Consultation Response from KC, Highways Development Management
2026/90096 Land Off, Ryecroft Lane, Scholes, Holmfirth, HD9 1ST
Reserved matters application pursuant to outline permission 2025/91464 for erection of residential development (one dwelling)
Date Responded: 15/07/2026 Responding Officer: D. Stainsby Responding Ref: K12-4/38

RECOMMENDATION:

As submitted the proposals are not acceptable to Highways. Details of car parking and waste storage and collection needs to be provided

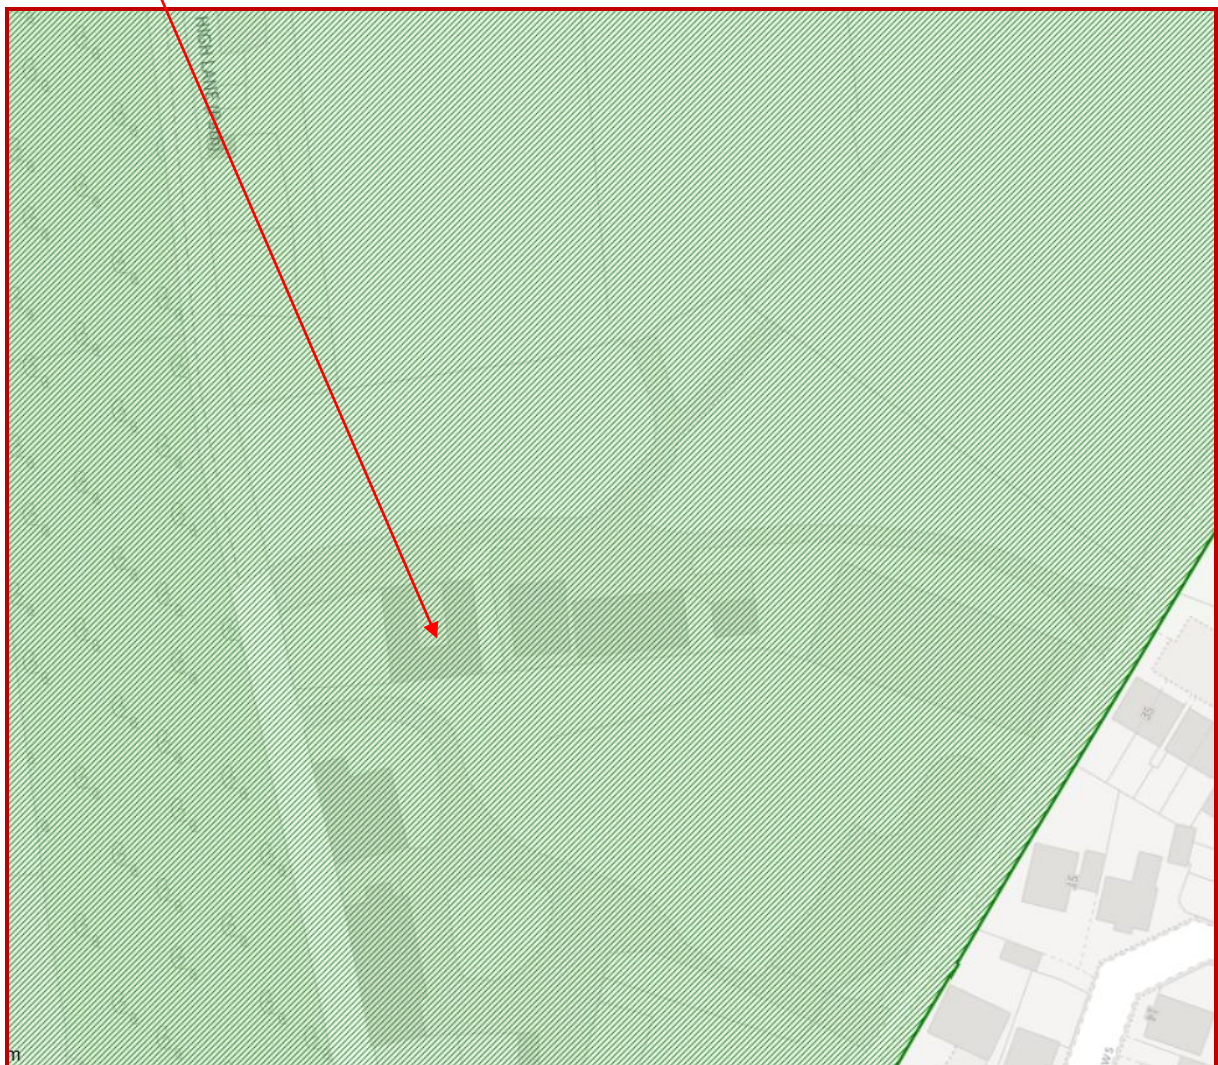
For a 3 bedroomed dwelling a minimum of 2 car parking spaces is required and a plan showing that the car parking spaces can be provided needs to be submitted.

The plan submitted does not appear to have any available space within the site to accommodate any car parking.

No bin store and/or bin collection/presentation point is shown on the proposed plans.

A bin collection/presentation point should be located adjacent to the public highway and must not obstruct the adopted highway or the driveway.

Details of the waste collection for the proposed dwelling should be provided, with the location of a waste collection presentation point being clearly marked on a drawing in such a location that is easily accessible to the collection team and where it will not obstruct the access or the adopted highway for road safety reasons.
